OUR REF: 603049-01000

**Re: Salvation Army Barrhaven Church – 102 Bill Leathem Drive TB
Addendum #1**

This Addendum has been prepared to address the comments received from the City of Ottawa with corresponding responses from Parsons. The most recent Site Plan is attached.

DRAWING TITLE
PHASE 1: SITE PLAN

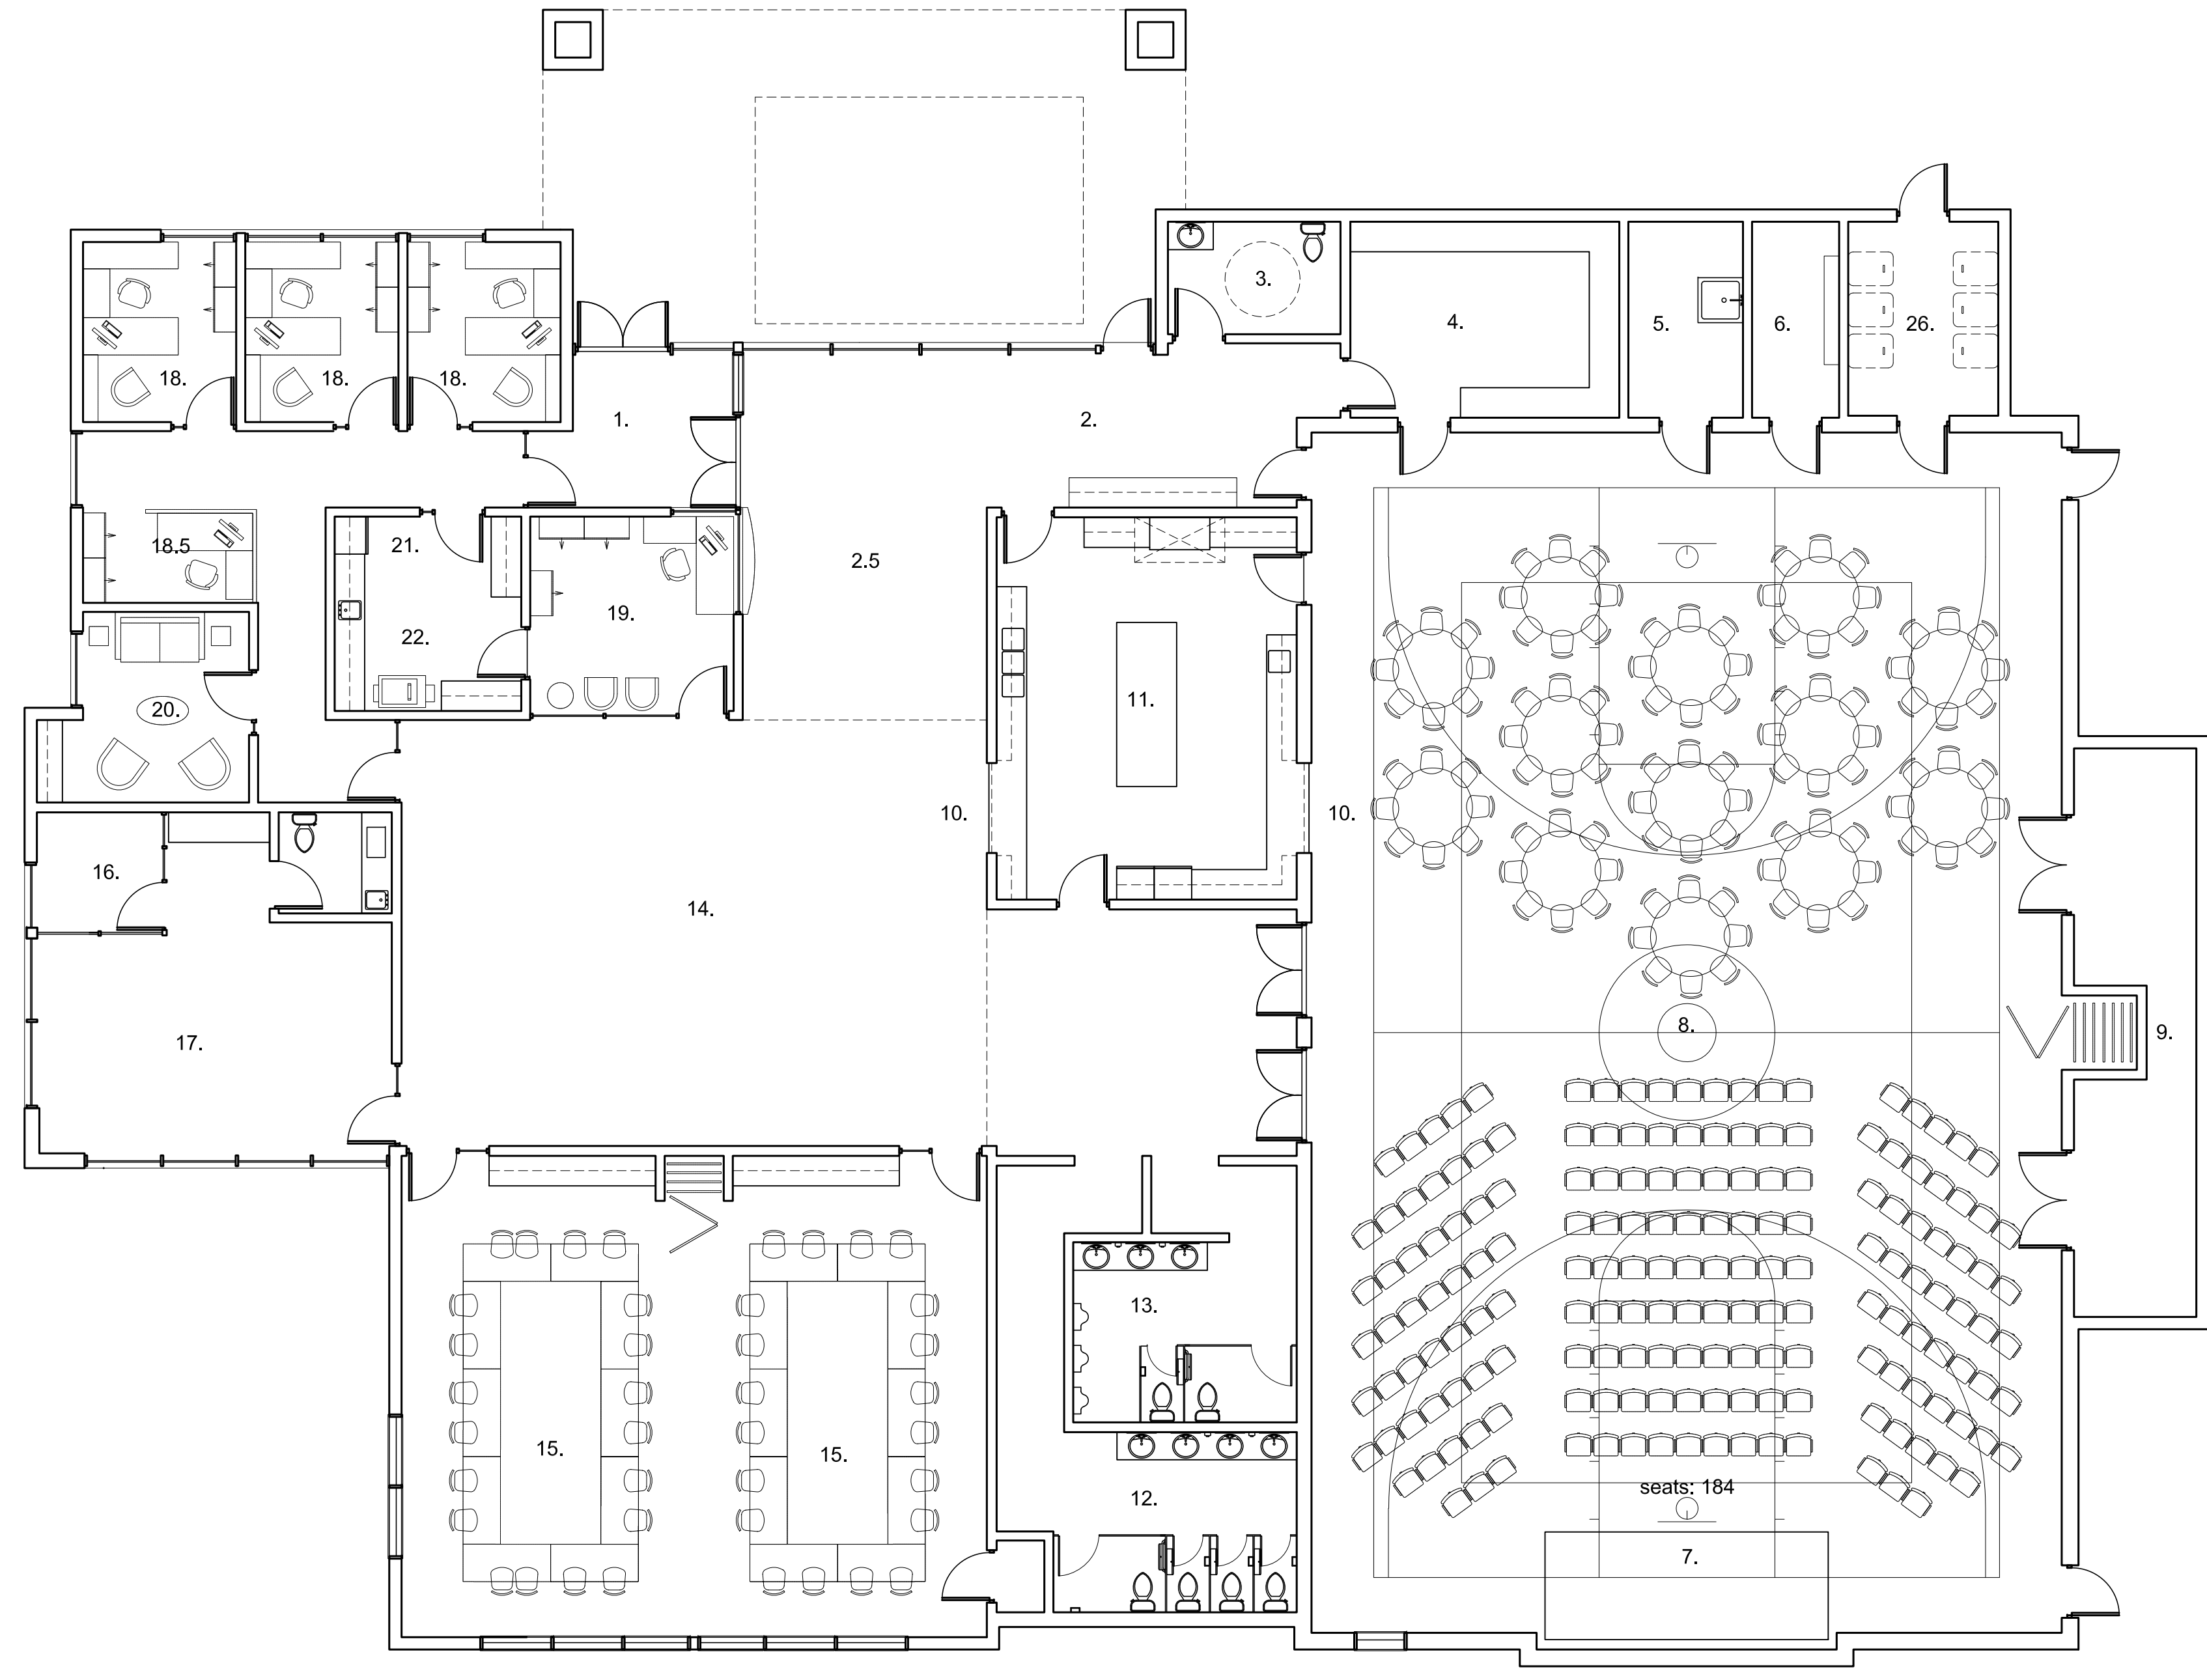
Comment E: *The bus stop #3753 is to be maintained. The applicant shall construct a new concrete shelter pad at no cost to the City, as per City specifications SC-11 attached. Consideration should also be given to extending the site along Leikin Drive in order to improve connections and provide pedestrian friendly amenities in the area. The site plan shall be revised to show how these transit amenities will be accommodated.*

Response E: The bus stop can be maintained given the proposed Site Plan. According to the revised Site Plan, a concrete sidewalk is planned along Leikin Drive as part of Phase 2 of the development.
